From: [Tucker Robinson](#)
To: [Alison Cantor](#)
Subject: Fwd: Space X Lease - Space Village Yards, Colorado Springs
Date: Thursday, September 10, 2026 9:49:29 AM
Attachments: [image002.png](#)
[image005.png](#)
[image007.png](#)
[image003.png](#)
[image004.png](#)
[image006.png](#)
[image008.png](#)
[image001.png](#)
[image009.png](#)
[image010.png](#)

Joe, this is regarding COM2613.

2) Please submit a revised Site Development Plan showing all existing and proposed activity on the site. The approved Site Development Plan we have on file (PPR233 shown below) does not depict the developments as shown in the imagery above. Or submit individual Site Development Plans per use. Please reach out to Planning and Community Development staff to submit the requested plans.

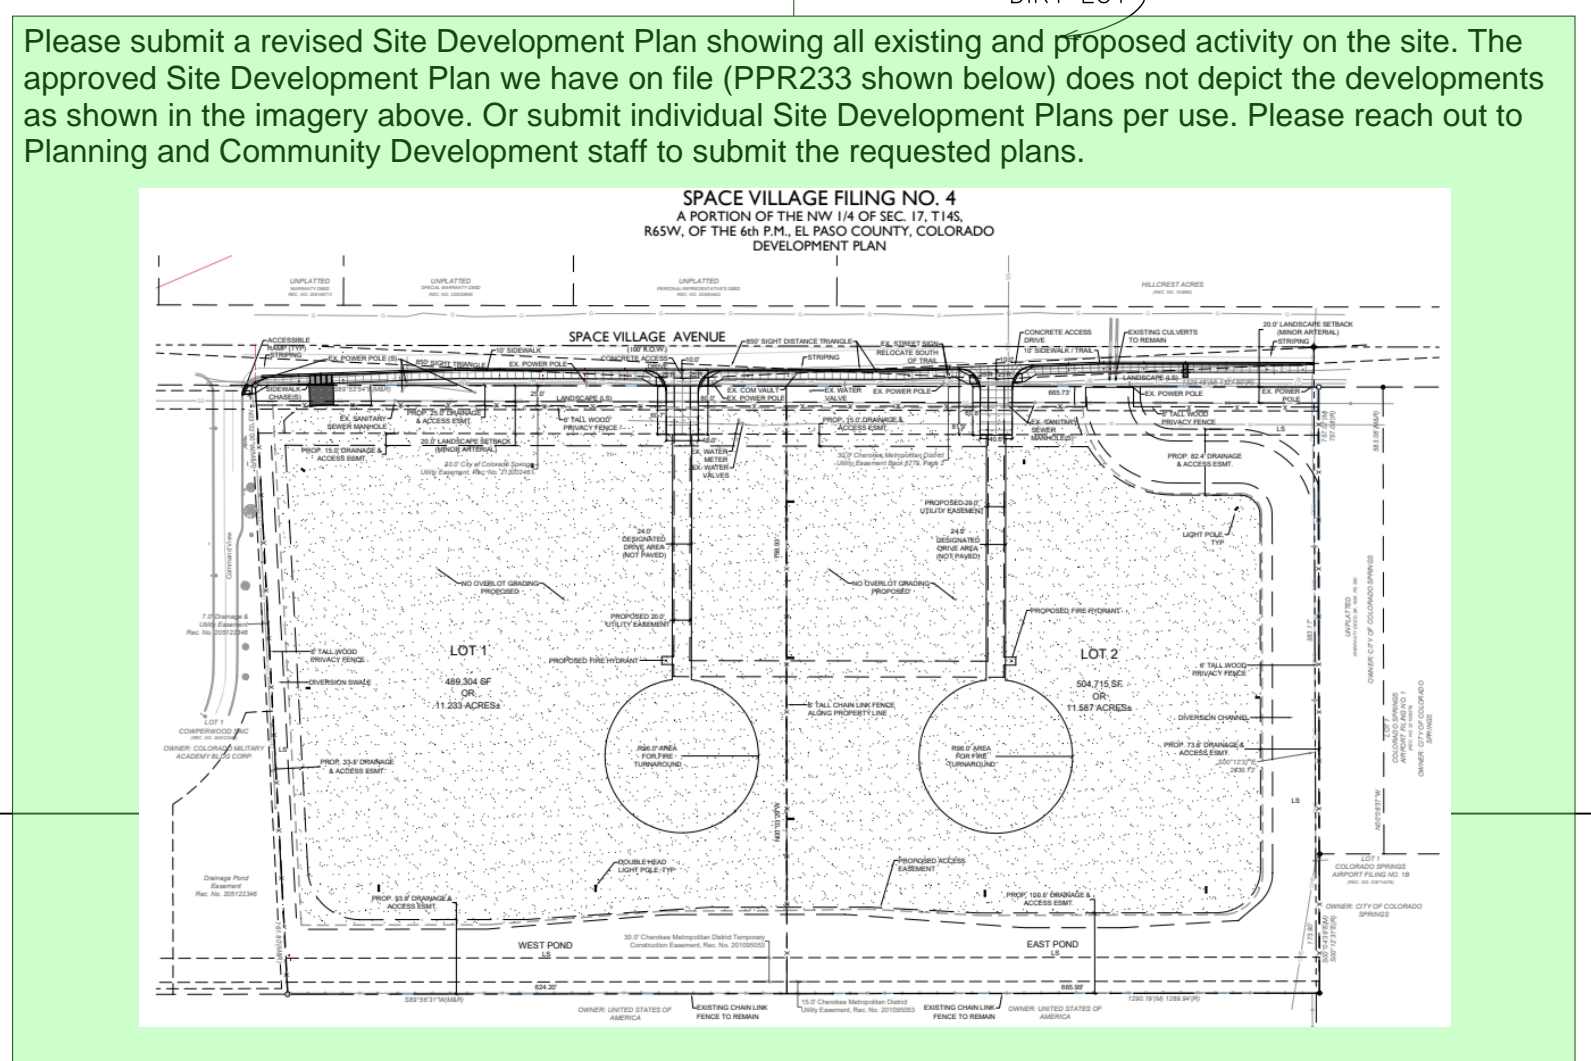
1. The red box drawn on the aerial image represents the only approved land use in the image The unapproved land use(s)

PROPOSED SITE PLAN

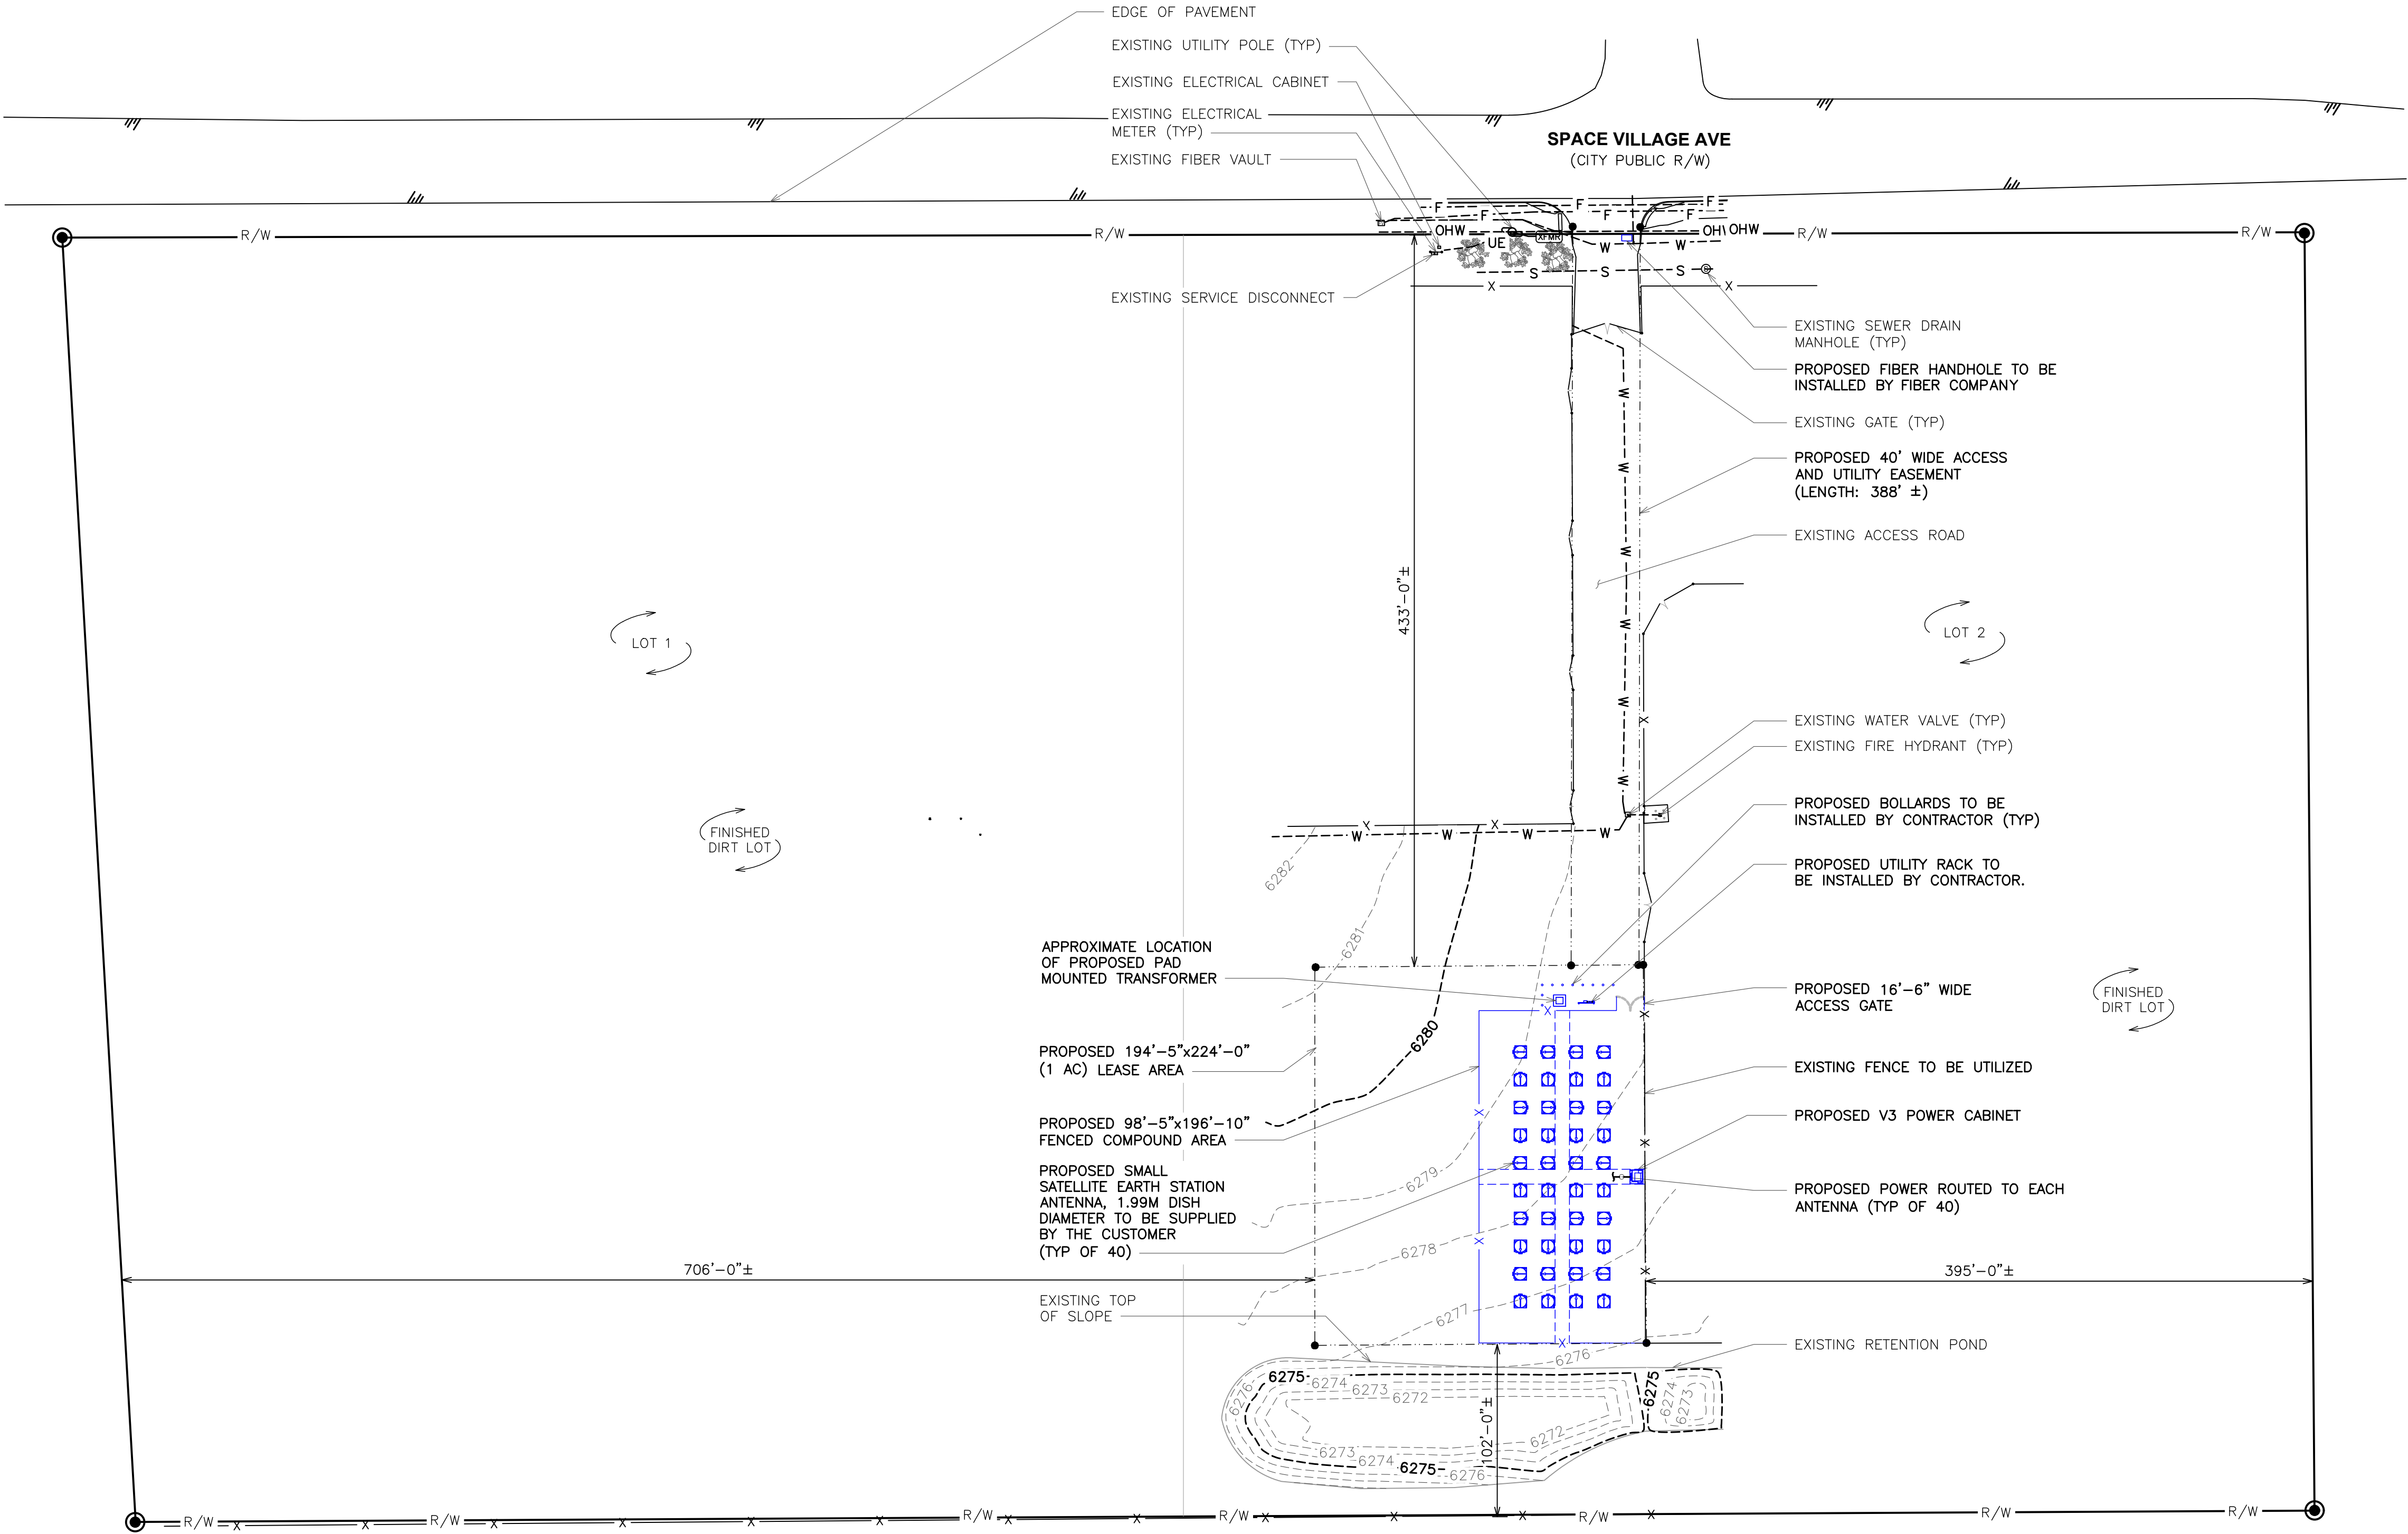
A joint access and maintenance agreement is needed as the applicant will need legal access as well as the physical access that is already available. The document will specify both legal access and the responsibility of maintaining the access (i.e. applicant, property owner, etc.). The easement will be recorded with the El Paso County Clerk and Recorder Office prior to the approval of this application. Minimum width is 24'. Show the access easement on this drawing and include the reception number (once recorded) and submit the recorded document via EDARP.

One of the comments we had back from the County requires us to record evidence of an access and maintenance agreement for the joint access to the site. I went ahead and drafted a Memorandum of Lease (MOL) that includes the access and maintenance language with our executed lease. Would you please review and let me know if there is any feedback? If everything looks good, please have the PDF version signed and notarized.
